28/10/2020

**Parramatta West Public School Redevelopment MOD 2 (SSD-8790-Mod-2)
Request for Additional Information**

Ground Floor - Demolition Plan - South Site B00B and B00D

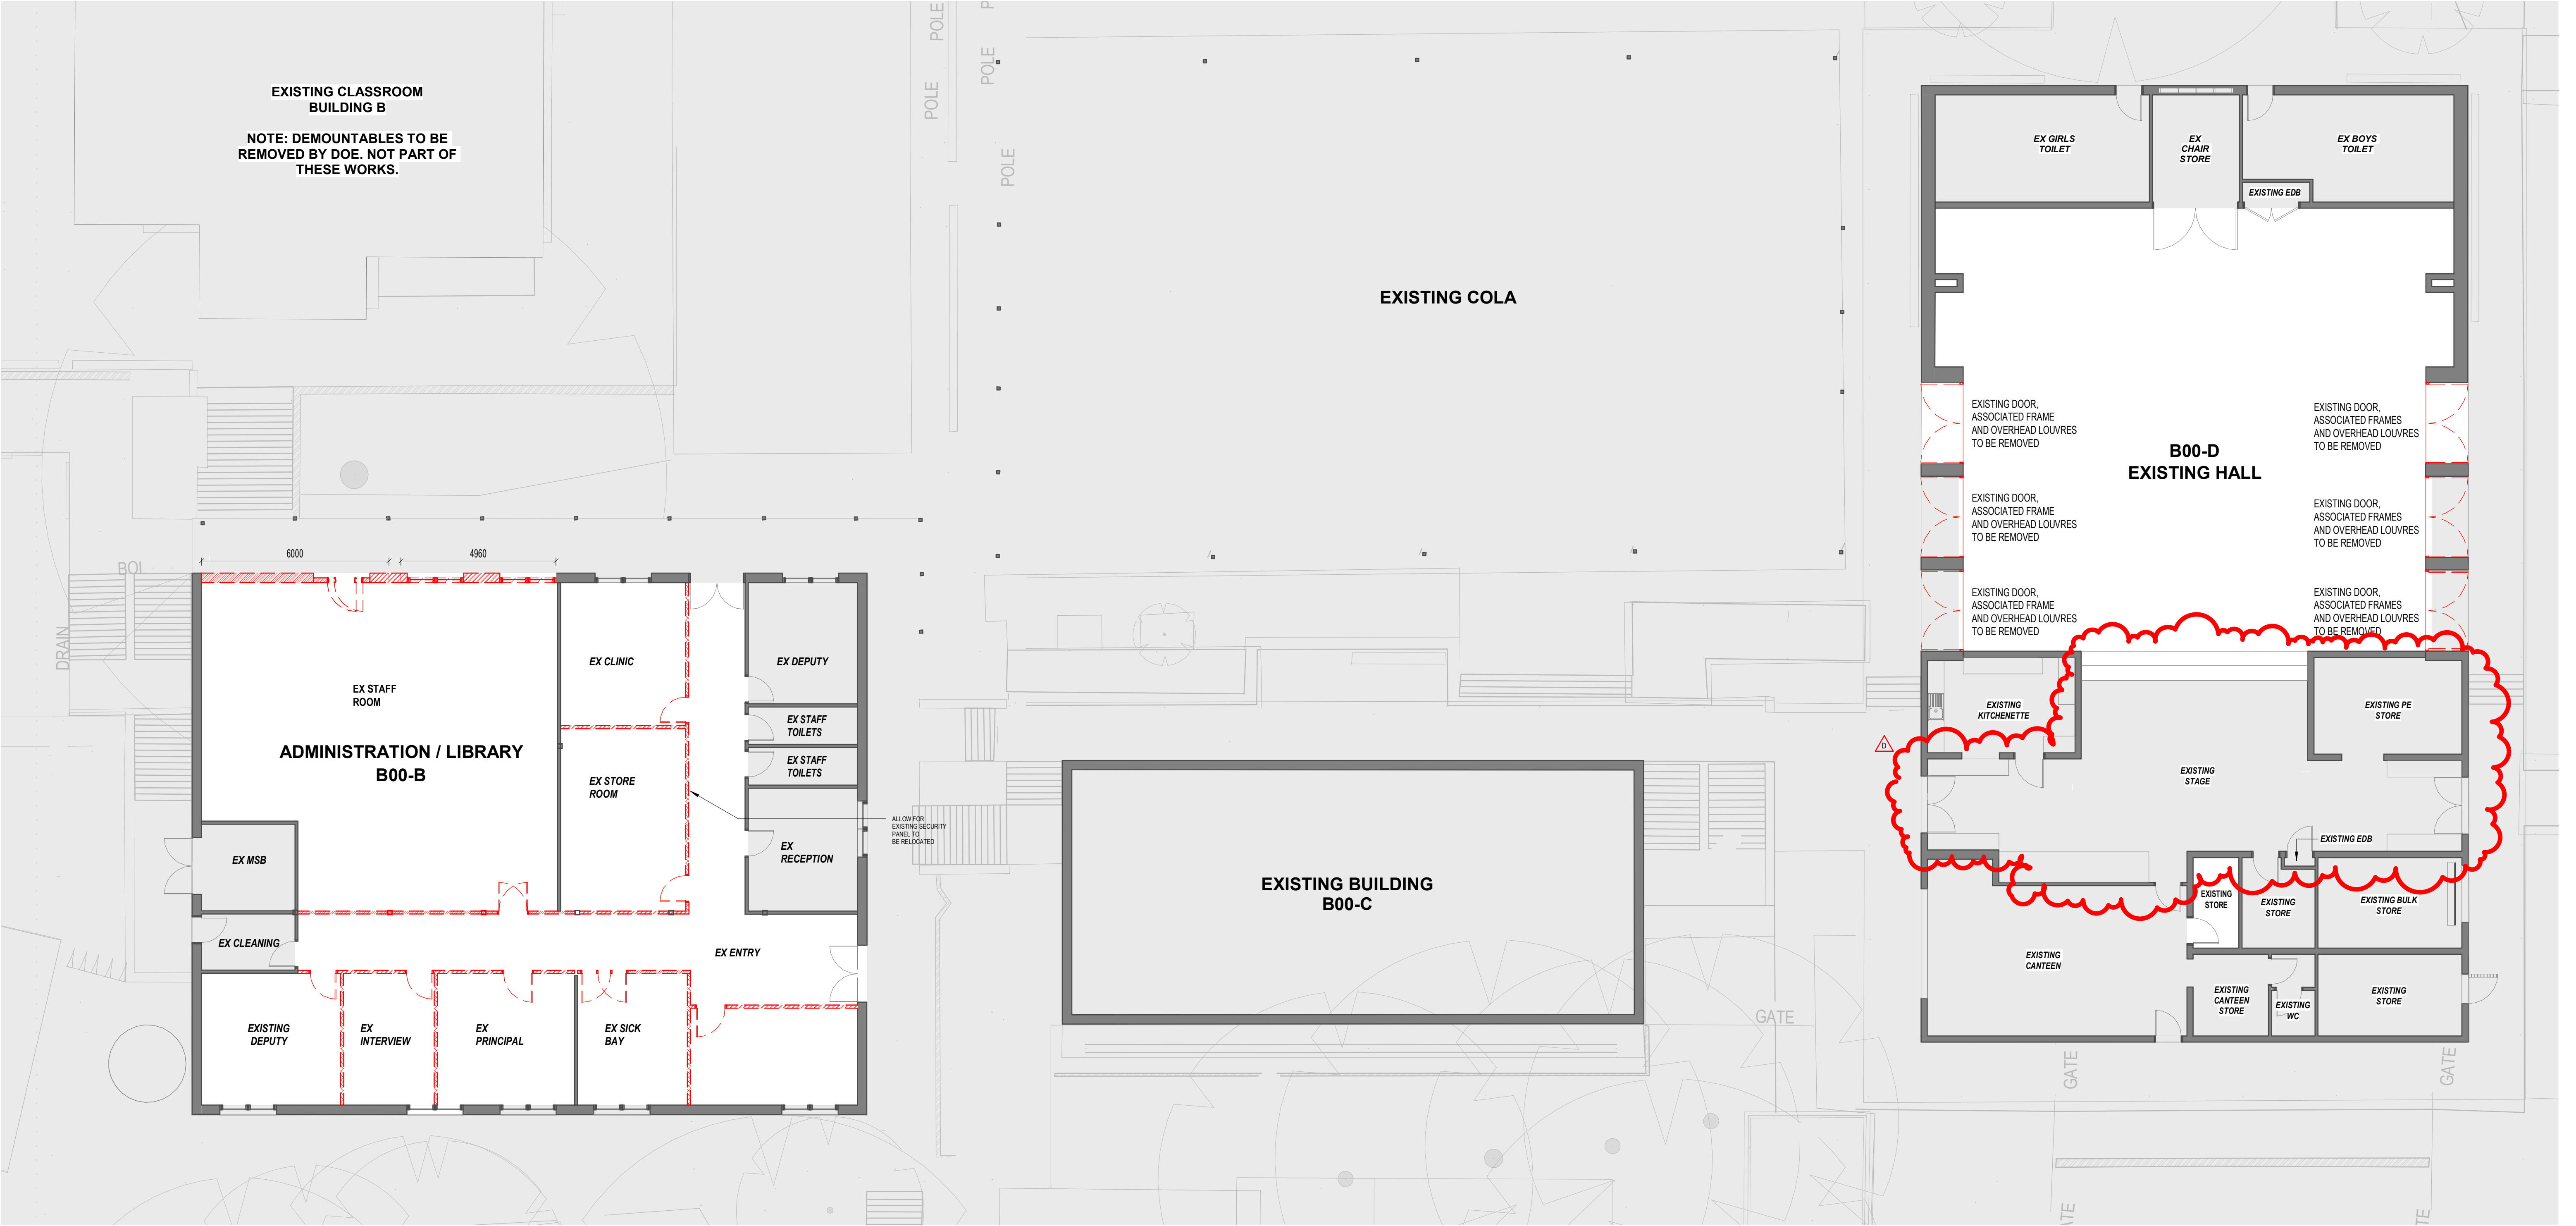
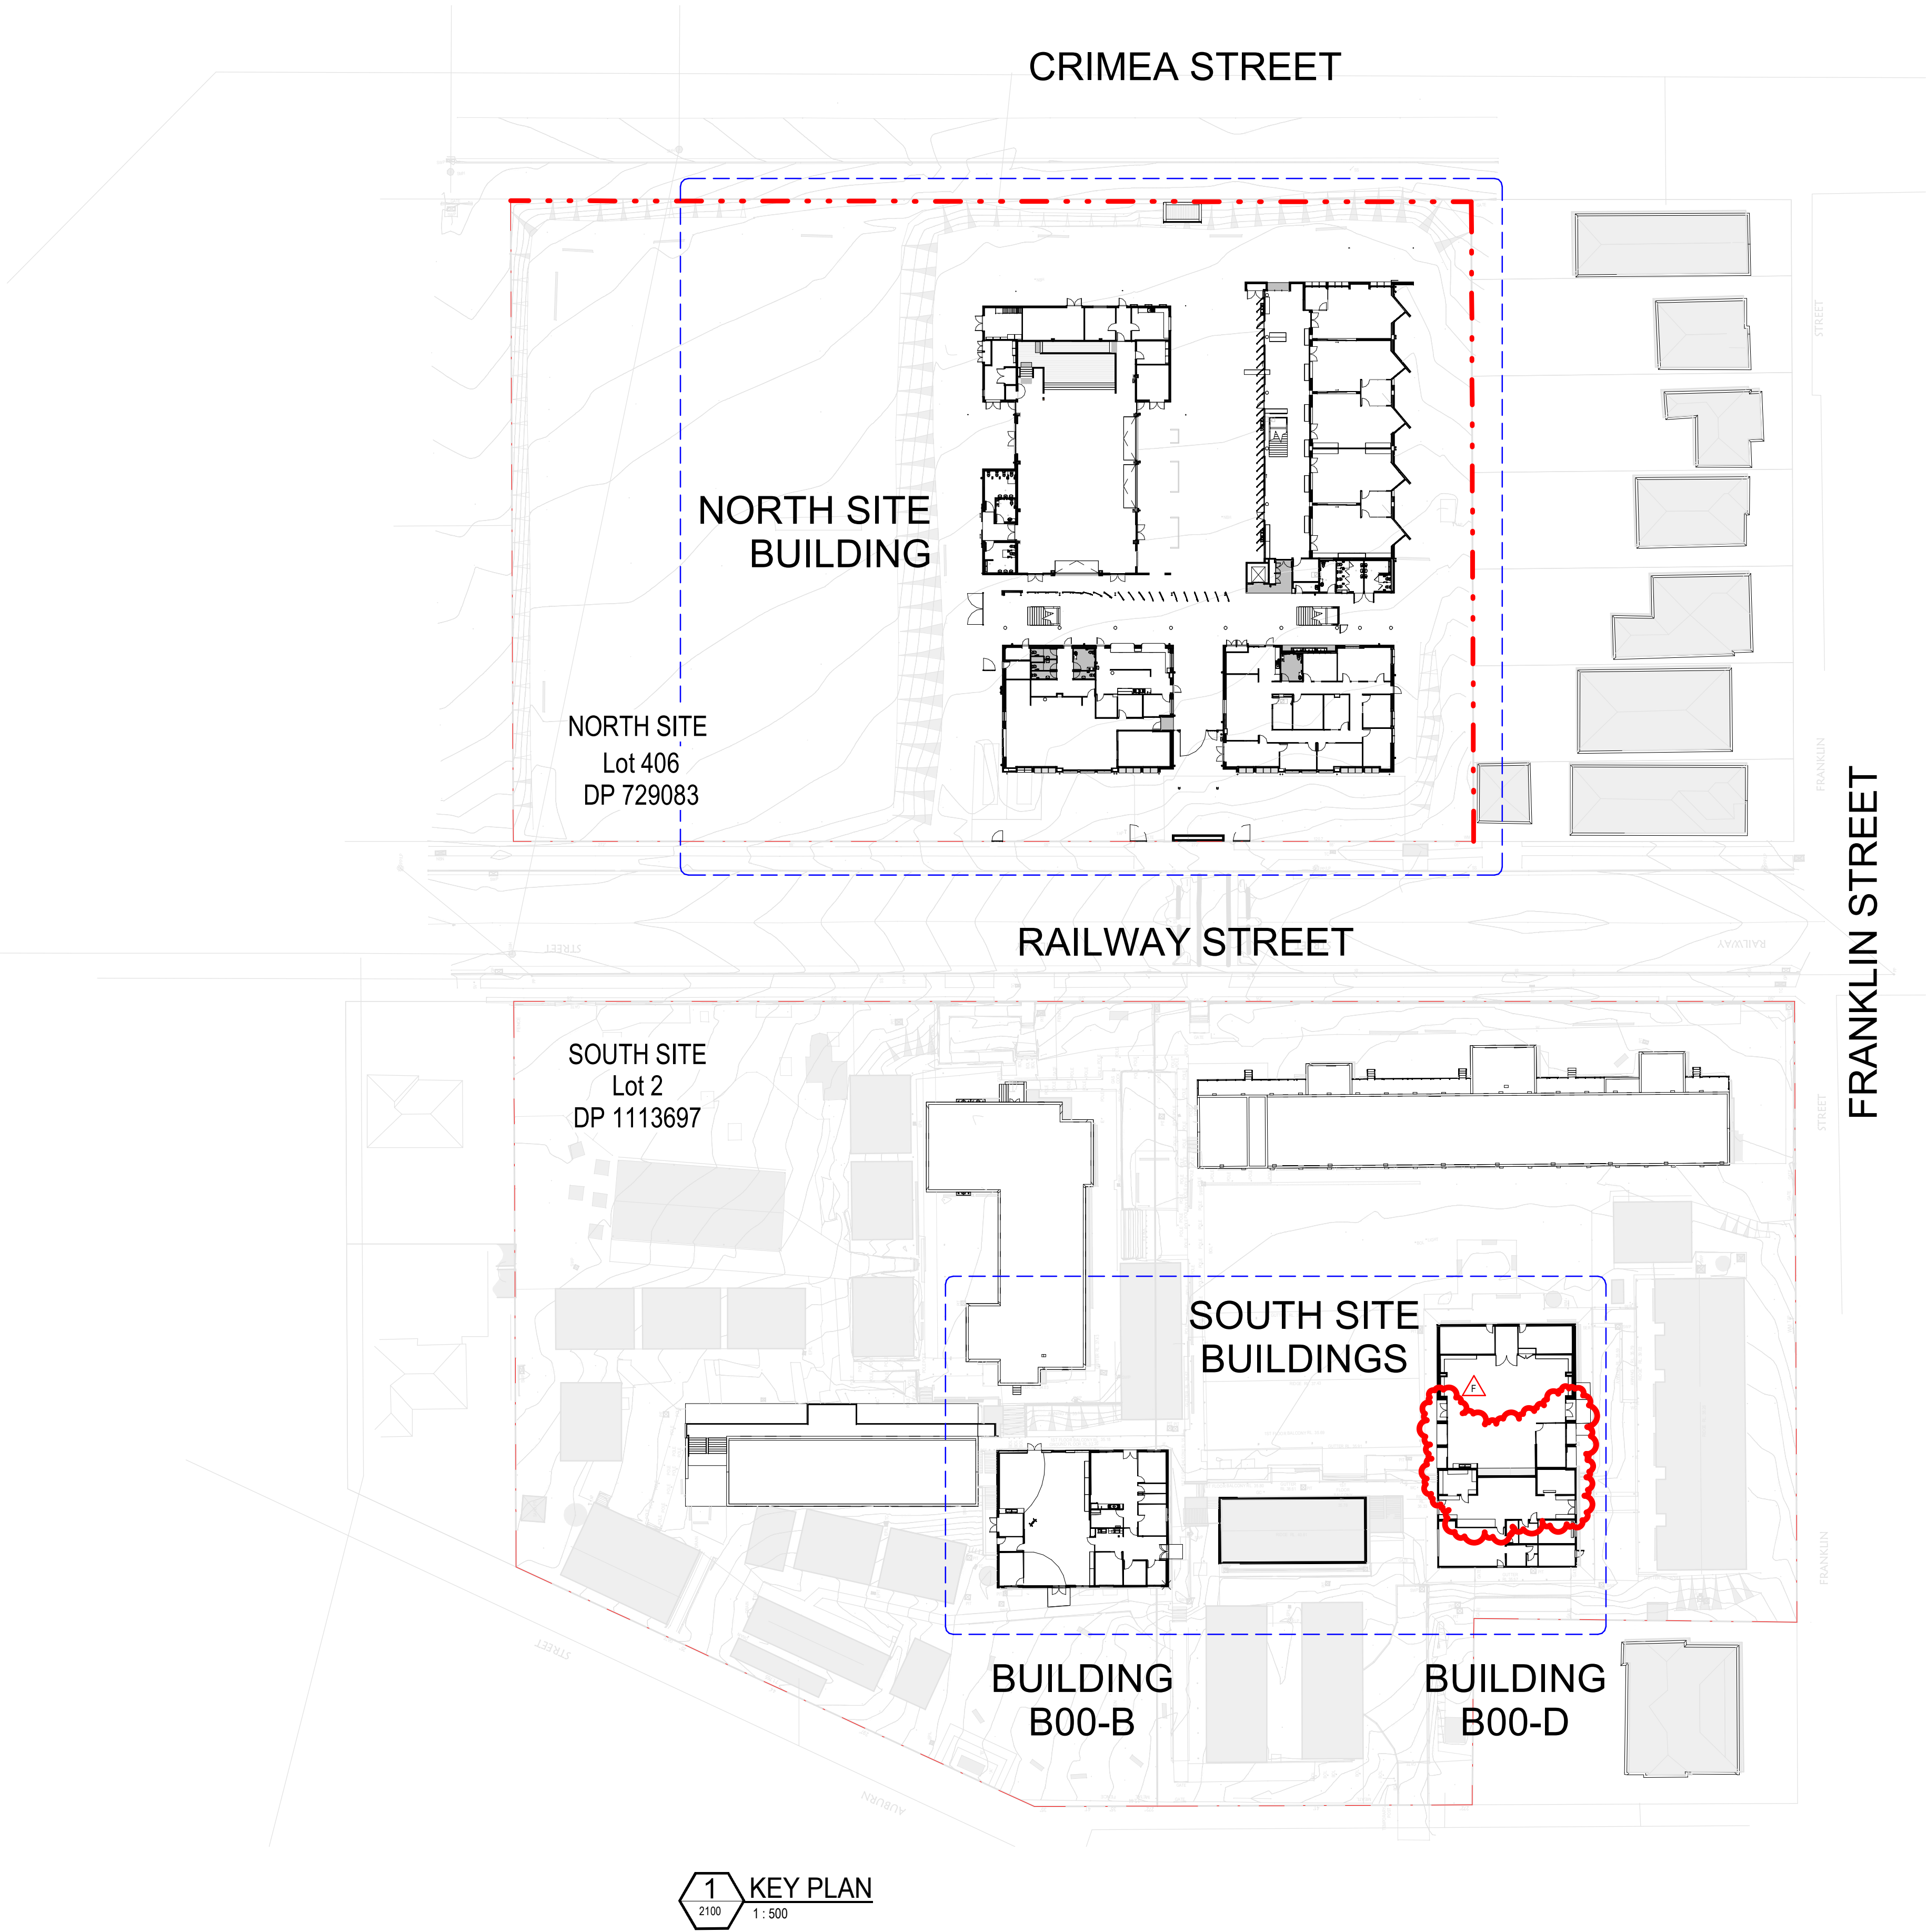
You are requested to submit revised architectural plans to replace the approved plan '*Ground Floor GA – South Buildings, revision E dated 27/5/2019*'. The plans provided as part of the Modification Application does not replace the approved plan and cannot be endorsed in its current form.
